ENG-CDR19004-R1-TIS-Redlines Summary_Markup Summary

Figure 10
 Year 2021 Total Traffic, Lane Geometry,
 Traffic Control and Level of Service

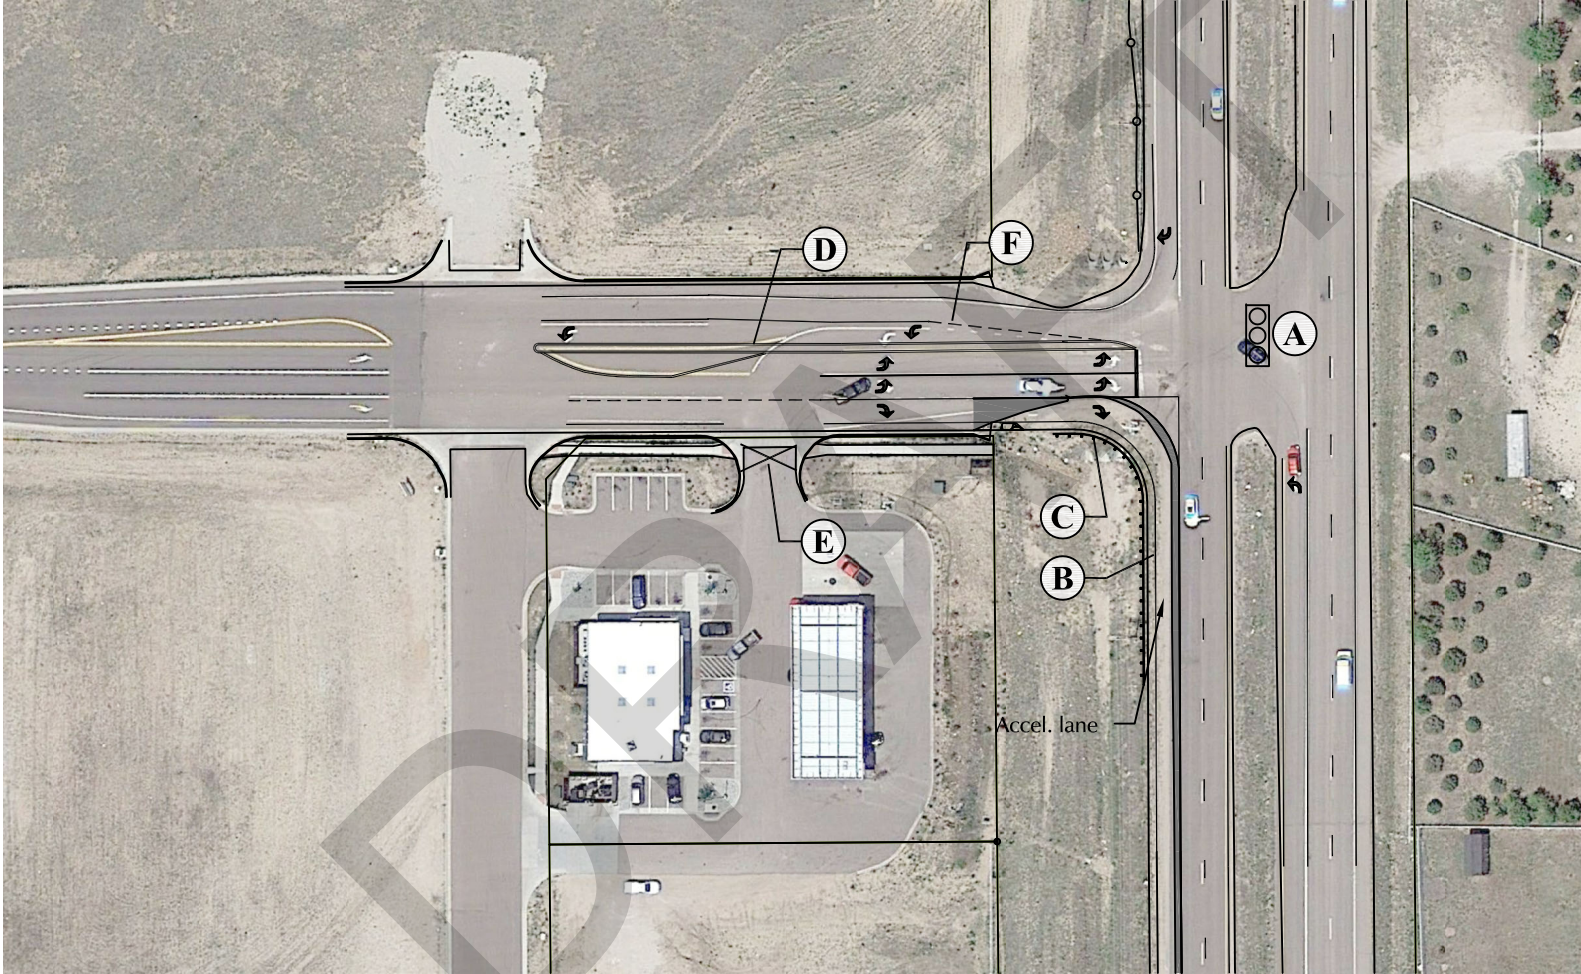
Add items from Figure 10.

label closure

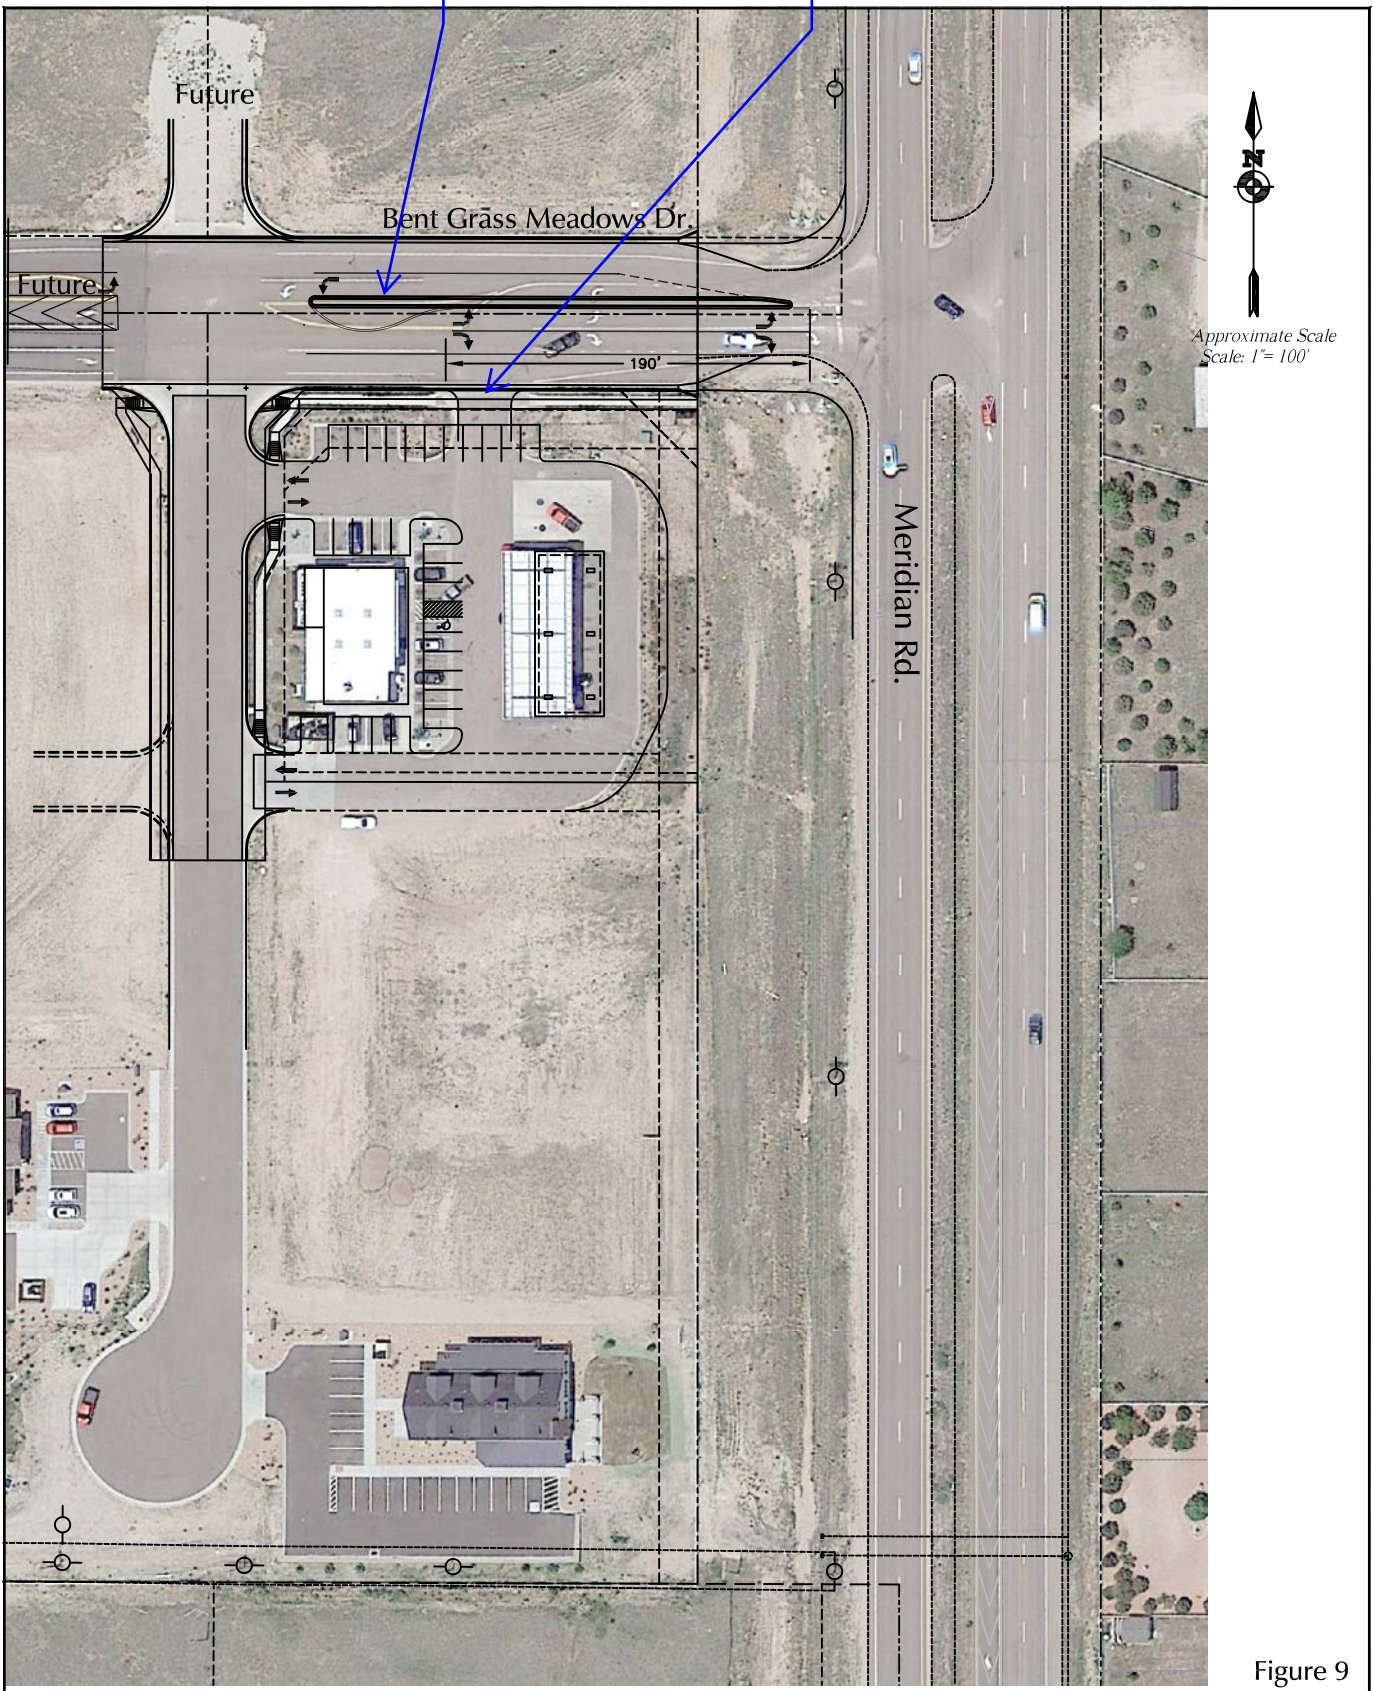
label median

label closure
